Comments on and objection to the proposed Padbury Brook Solar Farm planning application

I own and occupy Oldfields House, Mill Road which is one of the nearest residential properties to the site. I also regularly walk the public footpath which runs within the site that is accessed from Oldfields Copse. Although helpful discussions with the applicant's representative have alleviated some of my original concerns, I still have strong and fundamental objections to the scheme on certain grounds.

THE FOOTPATH WILL BE WIDENED TO 10M, AND ENSURE GREATER ACCESSIBILITY FOR LOCAL RESIDENTS.

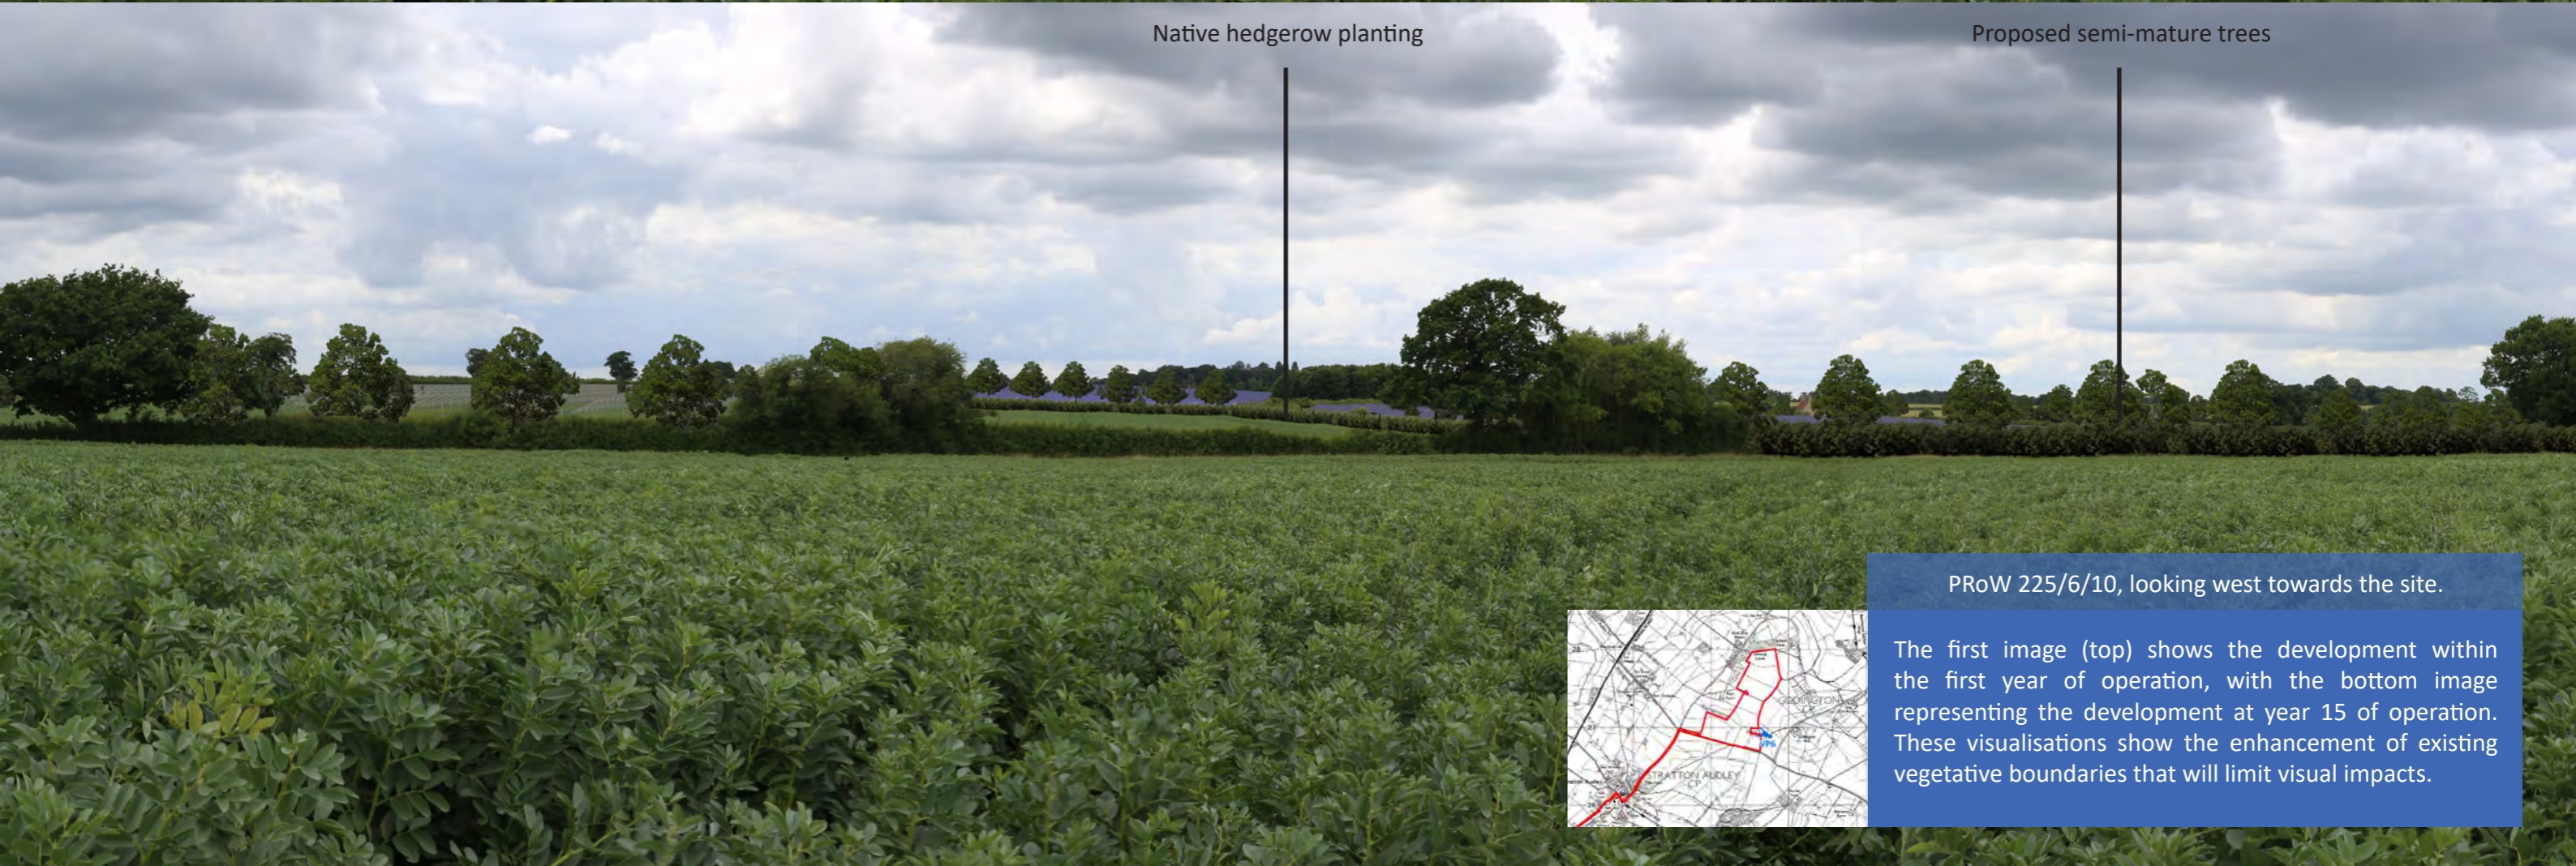
This section of the footpath is very well-used. It is one that I walk regularly, and I usually observe others doing the same. The views across the open fields contribute particularly to the enjoyment that is gained. The suggestion that the public footpath will be enhanced is refuted. There is no need for it to be widened or surfaced – once a footpath always a footpath with the access safeguards that that entails. The route is already of ample width to provide safe and easy access. Its surfacing would detract from rural character.

Appendix D: Model Noise Contours

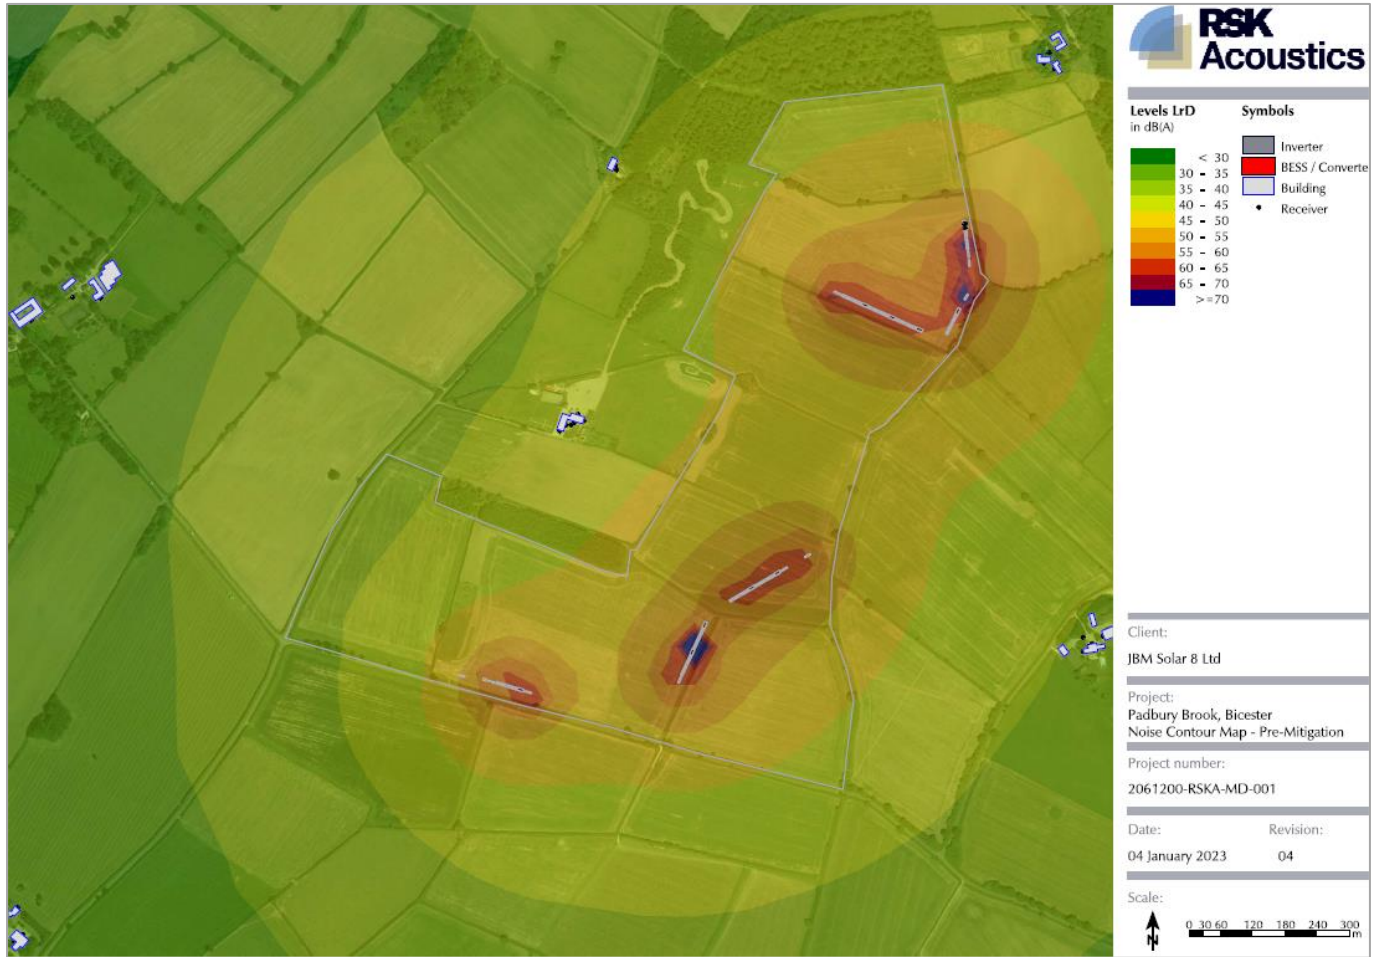
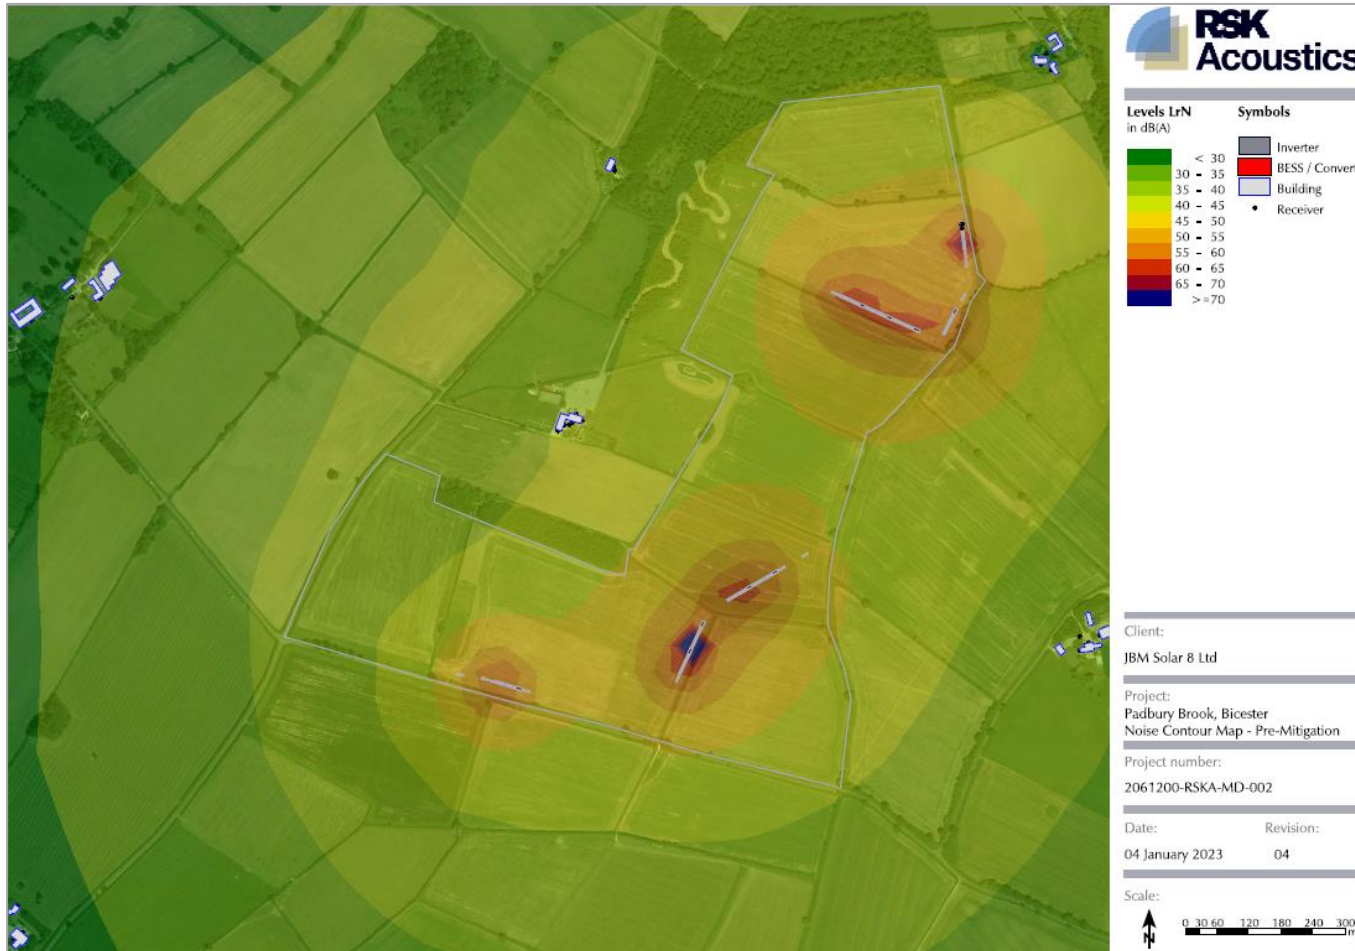
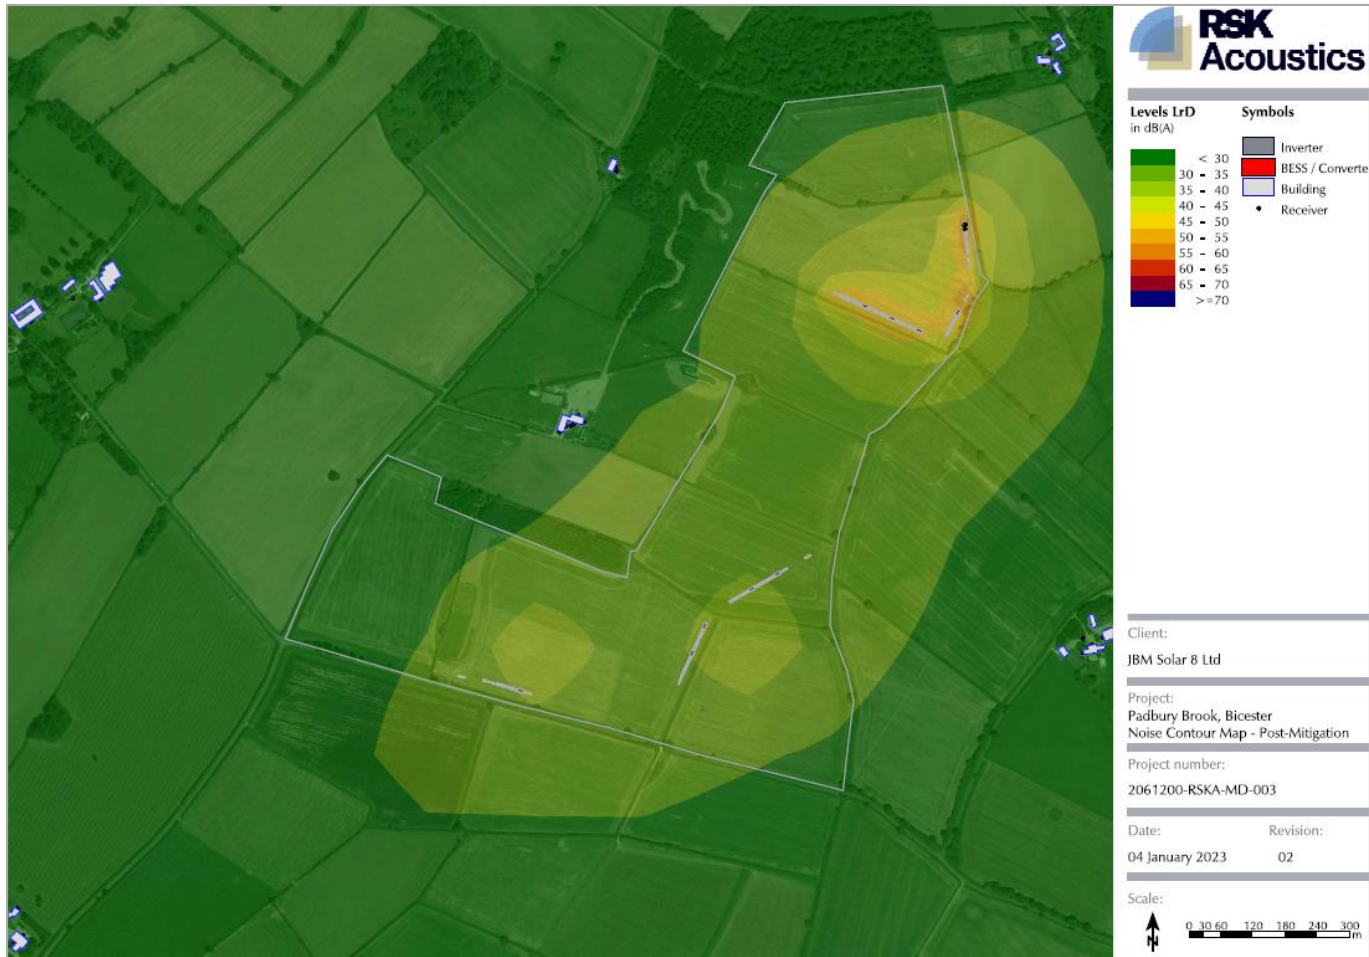
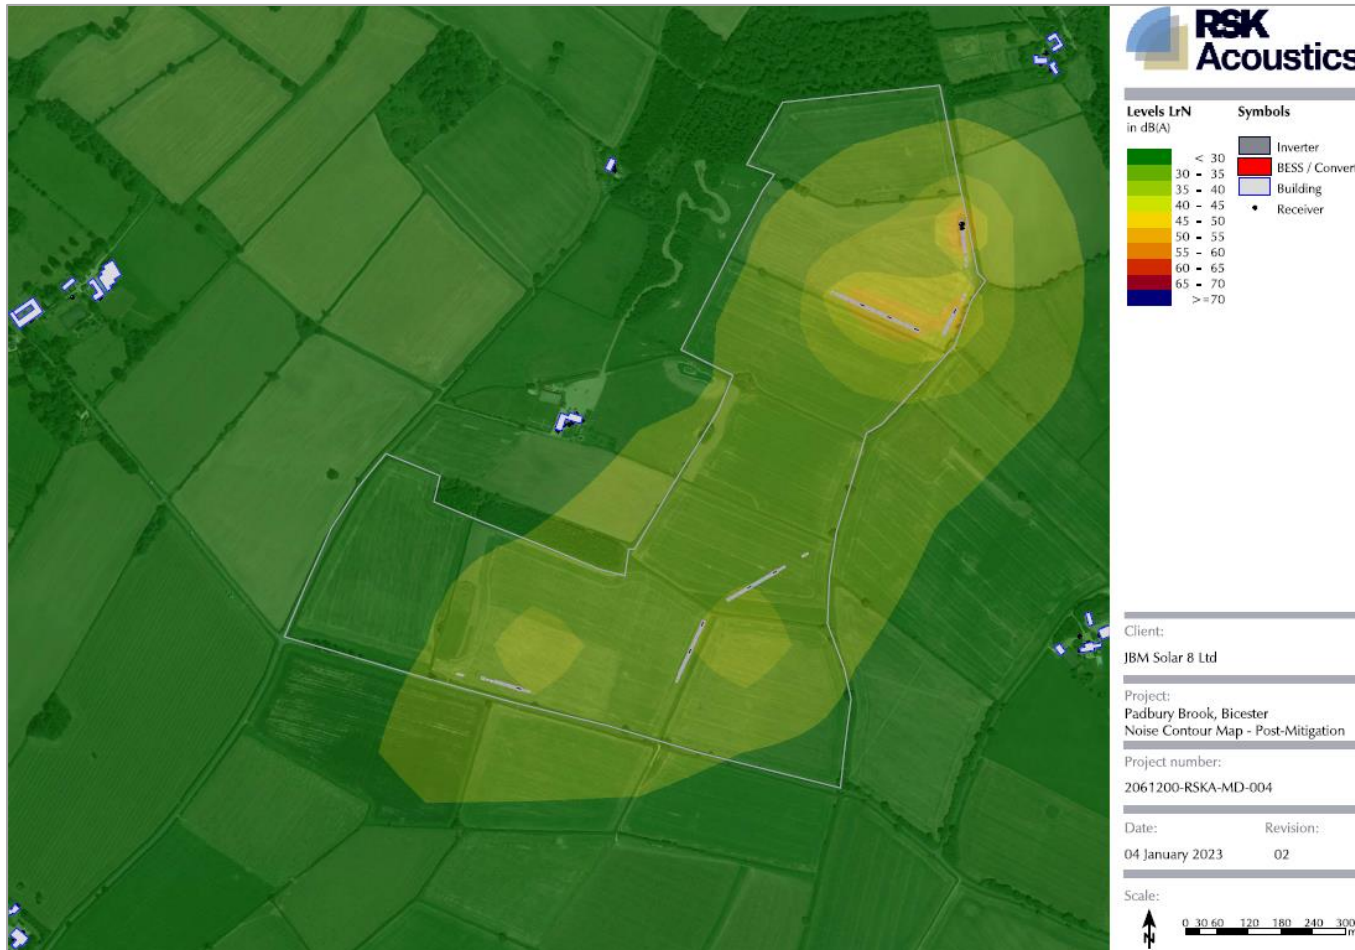
This concludes that predicted Rating Levels from the development would be in excess of 10dB above the prevailing background level at my property during the day and in excess of 21dB over background levels at night. The same applies to other neighbours.

The key point is that BS 4142 states that a difference of around +10 dB or more is likely to be an indication of a significant adverse impact. Indeed, a difference of around +5 dB is likely to be an indication of adverse impact.

Thus, there is likely to be a significant adverse impact on the amenity of neighbours including myself due to noise disturbance. The noise assessment also reveals that these are very noisy items of plant that would also detract from the experience of users of the existing public footpath and the new permissive path.

Nevertheless, I have recently had most helpful discussions with a representative of the applicant regarding my concerns in this respect. It has been indicated to me that full enclosure of the noisy items of plant including the BESS, and the inverters will be provided, as indicated by the working example in the Noise Impact Assessment, so that there would be no increase in noise over and above existing background levels experienced by residents. This would be confirmed by the submission of a revised Noise Impact Assessment by the applicant, and secured by planning conditions. In addition, the site layout plan was amended prior to submission of the application to remove such items from the northernmost field that is closest to my home and that of my immediate neighbour. A planning condition is necessary to ensure the development takes place in accordance with the submitted plans.
